OXFORDSHIRE COUNTY COUNCIL'S RESPONSE TO CONSULTATION ON THE FOLLOWING DEVELOPMENT PROPOSAL

Application no: 16/00263/F-2

Proposal: Demolition of Buildings 485 and 488 and the erection of 43 dwellings with associated parking, infrastructure, landscaping and public open space.

Location: Buildings 485, 488 And Land Surrounding Those Buildings (Dorchester Phase 6)
Heyford Park Camp Road Upper Heyford

### **Proposed levels and drainage layout**

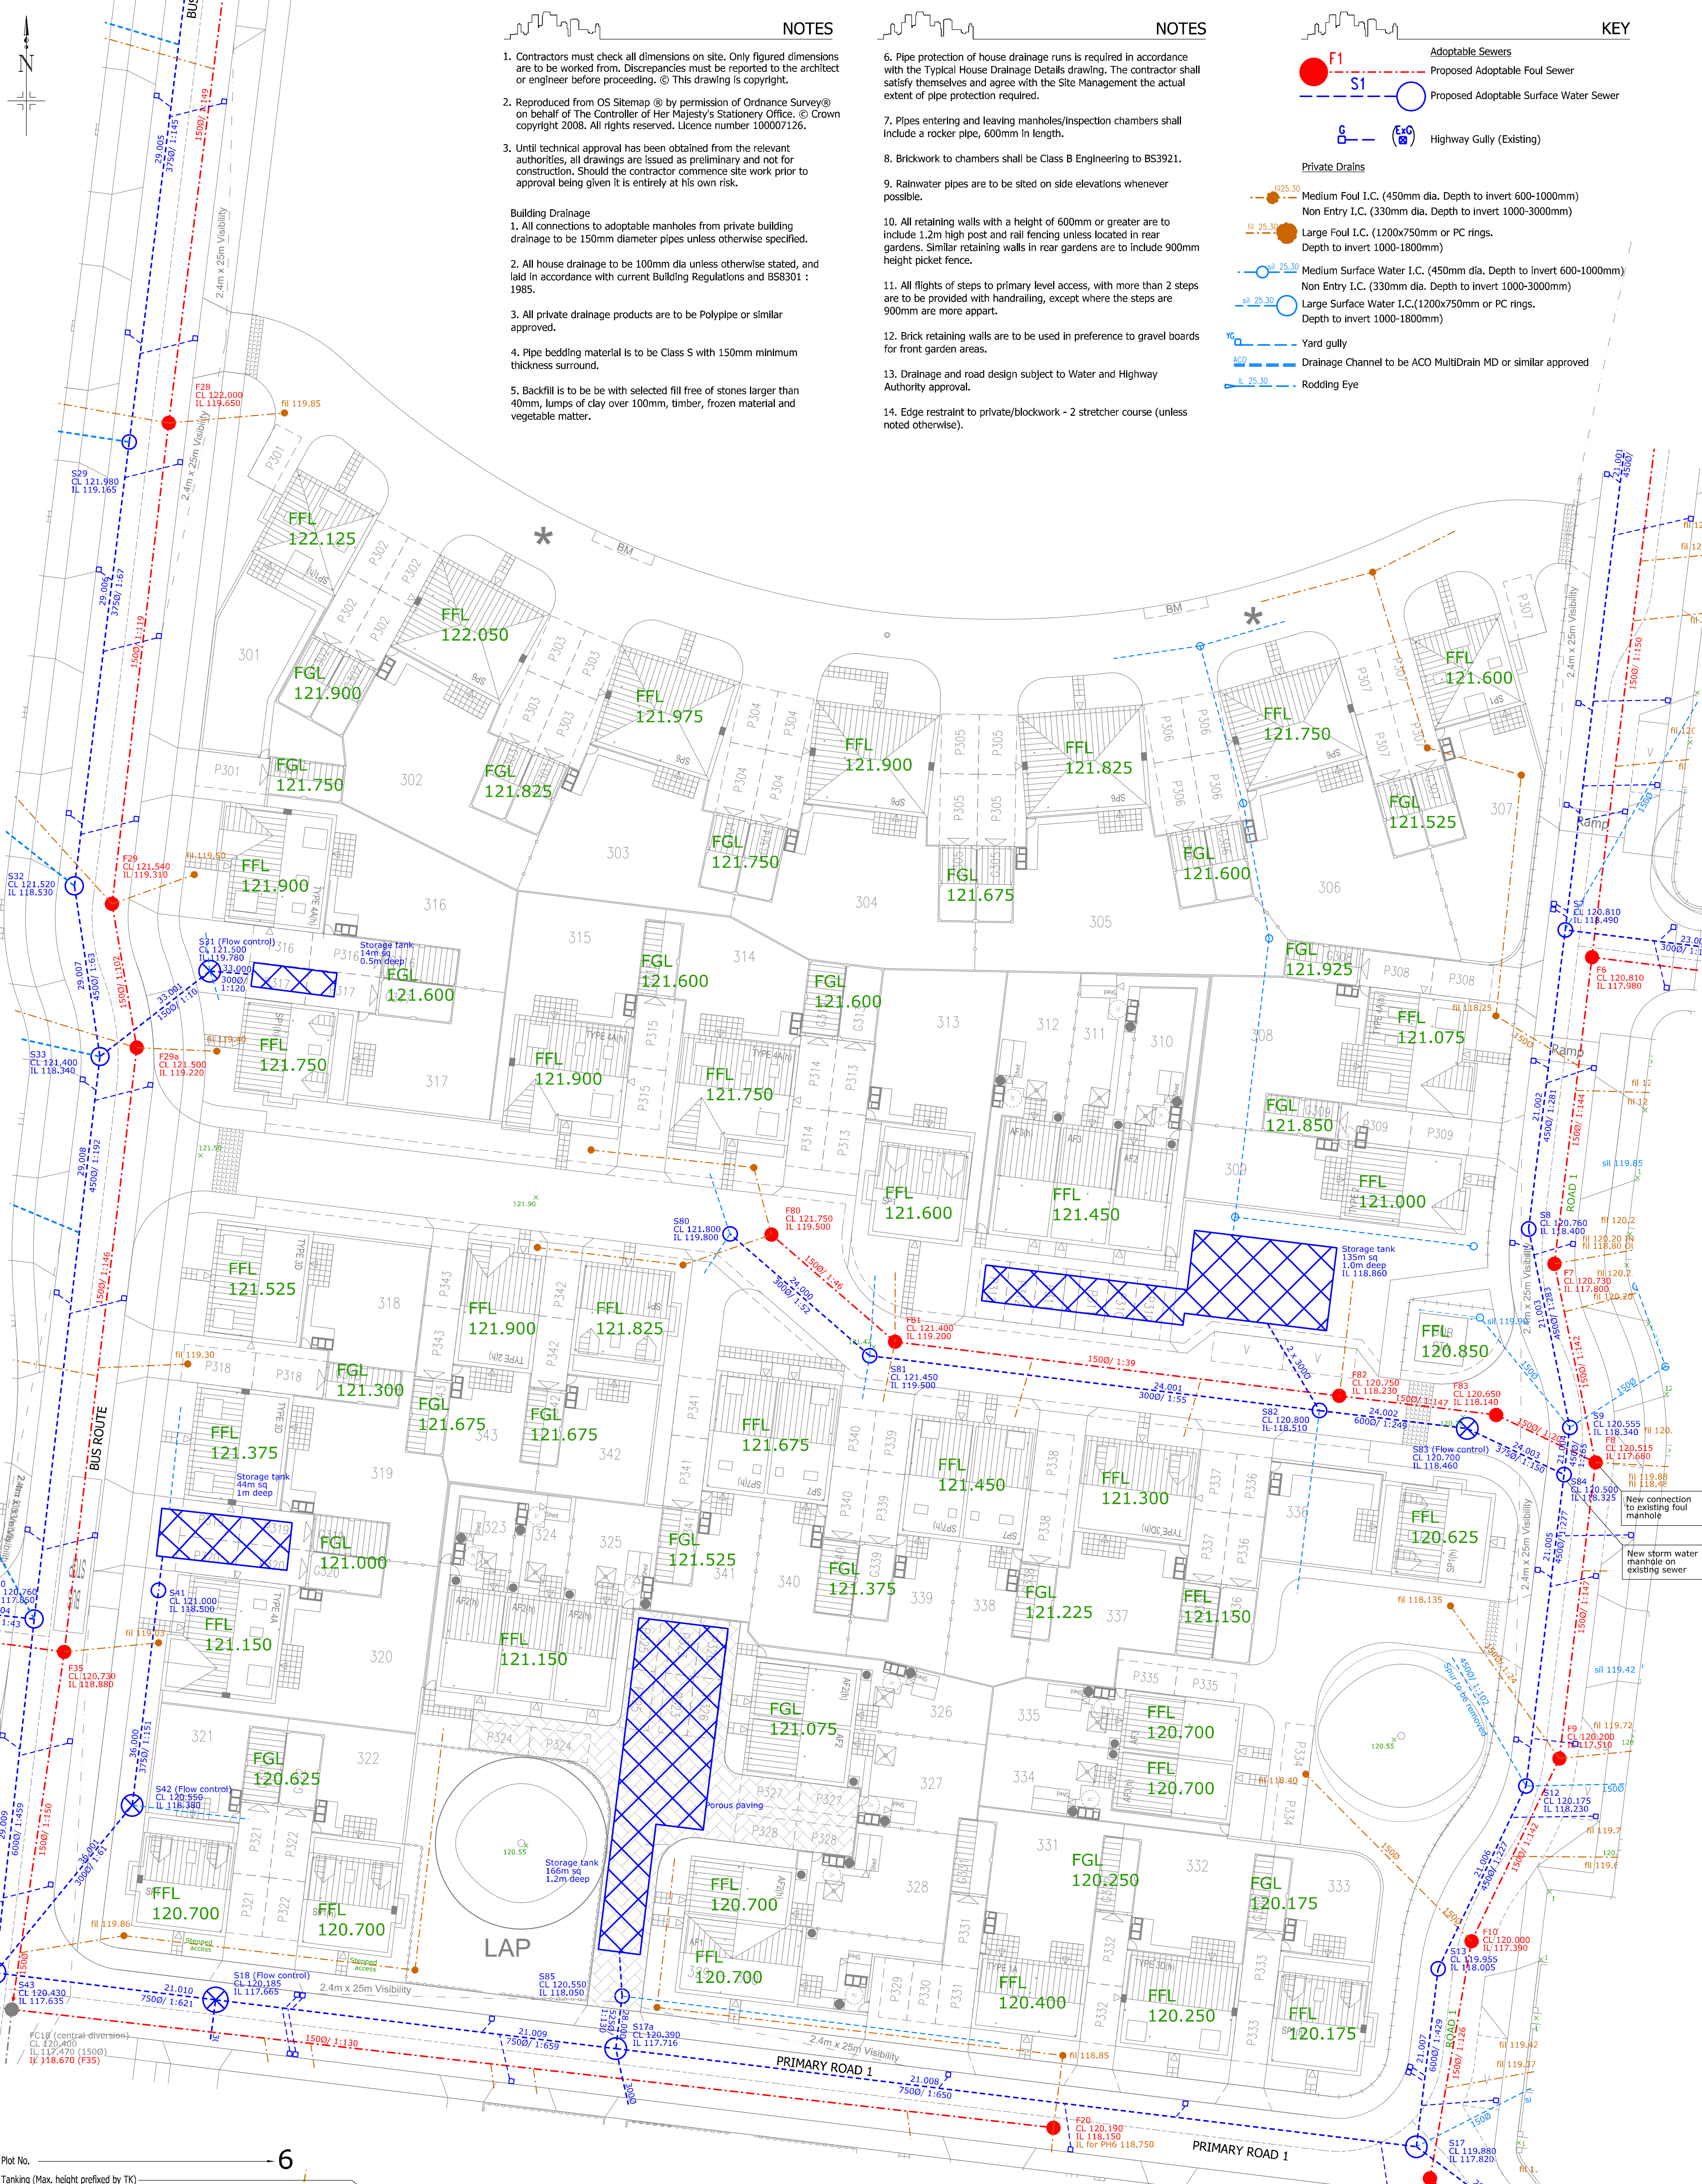
- *Limiting the surface water run-off generated by the 1 in 100 year + 30% allowance for Climate Change critical storm so that it will not exceed the run-off over the existing situation and not increase the risk of flooding off-site.*
- *Underground Storage tanks and oversized pipes. (As shown on drawing HEYF- 5-936C and para 6.3.1 of FRA update)*

Detailed design of the outfall structure at the Gallos brook including section showing levels are not included in the planning application documents. However, it is understood that the outfalls are already constructed and drawings can be provided if required.
